# CITY OF ALBUQUERQUE

**Re: Dolores Gonzalez E.S., 900 Atlantic Ave. SW, Grading and Drainage Plan  
Engineer's Stamp Dated 03-28-2013 (K-13/D031)**

**SITE/GRADING &
DRAINAGE PLAN**

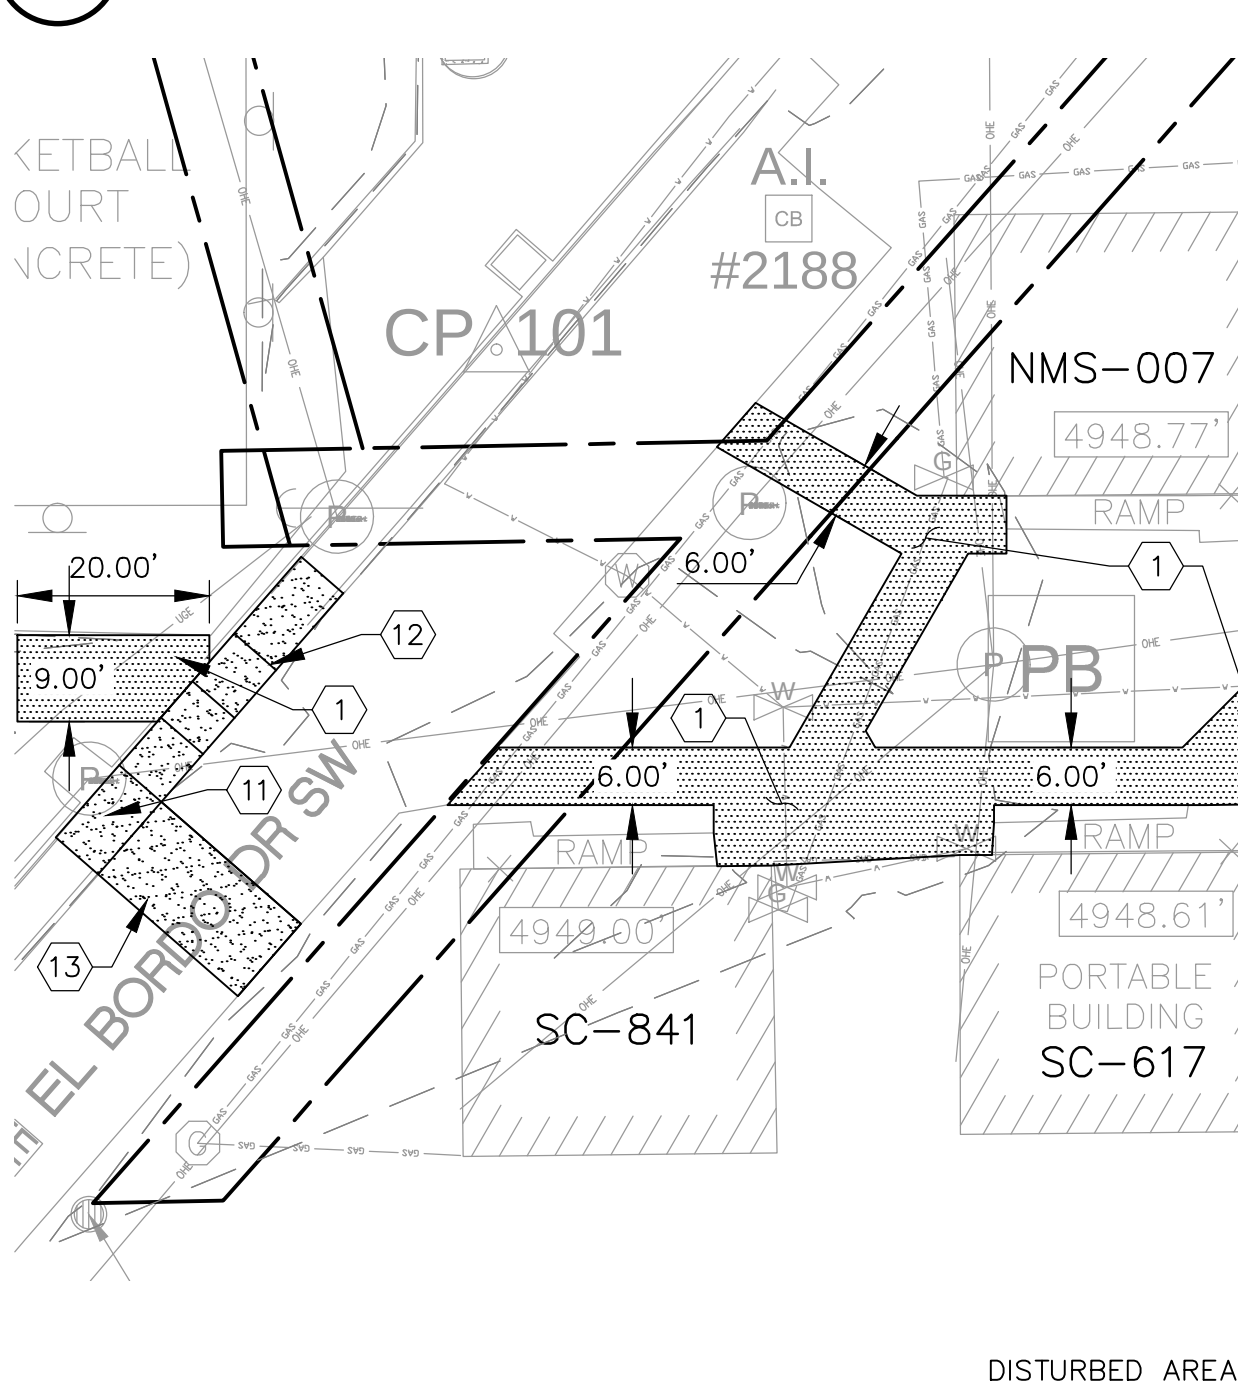
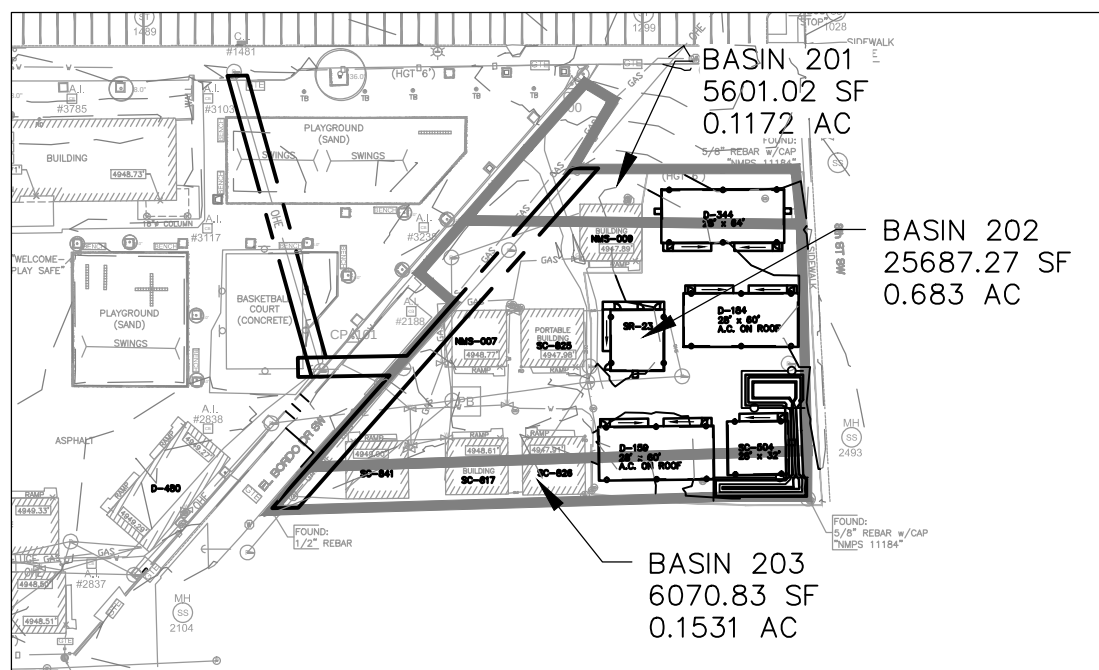
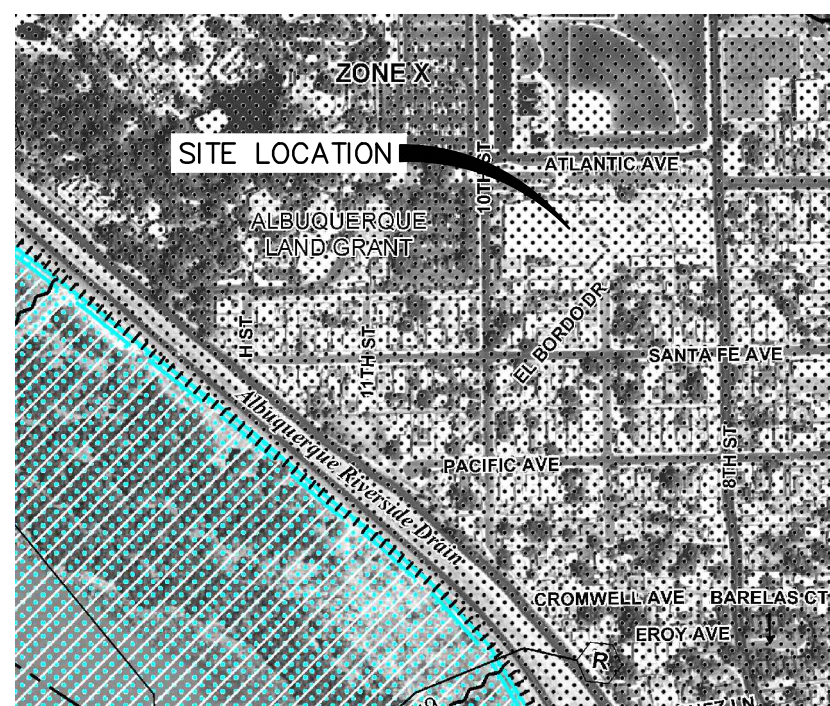
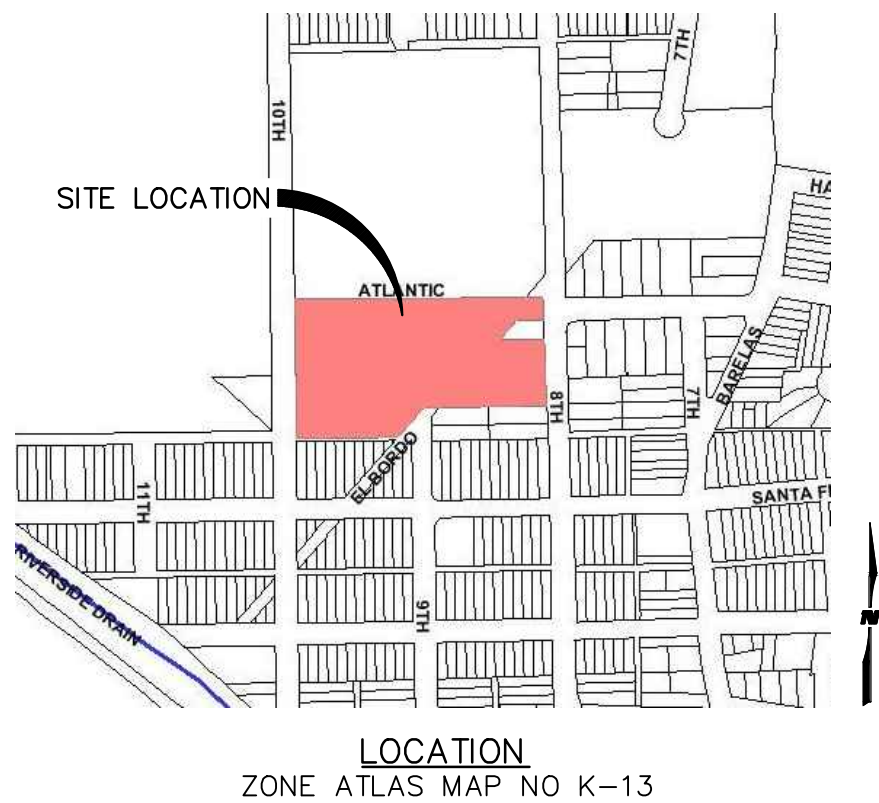
- Provide additional spot elevations to show how flows are directed to the proposed ponding areas. How do flows from Basin 201 & 202 enter the proposed sidewalk culvert?

- Proposed discharge from Basin 201 & 202 is 2.93 cfs and the capacity of the associated sidewalk culvert is only 1.5 cfs; how will this culvert function?

- Allowable peak discharge for this site will be limited to 2.75 cfs/acre due to its location. The required pond volume due to this restriction should be around 1100 ft<sup>3</sup>, an increase from the provided 610 ft<sup>3</sup>.

- The existing drivepad on the southeast corner of the lot is no longer in service and should be closed. Flows from Basin 203 will not be allowed to discharge across the sidewalk.

- Add a note to Keynote #7 calling for the bolts to be tack welded to the steel plate cover and to extend the plate 2 ft from the back of sidewalk.
- Please provide flowlines along 8<sup>th</sup> Street.
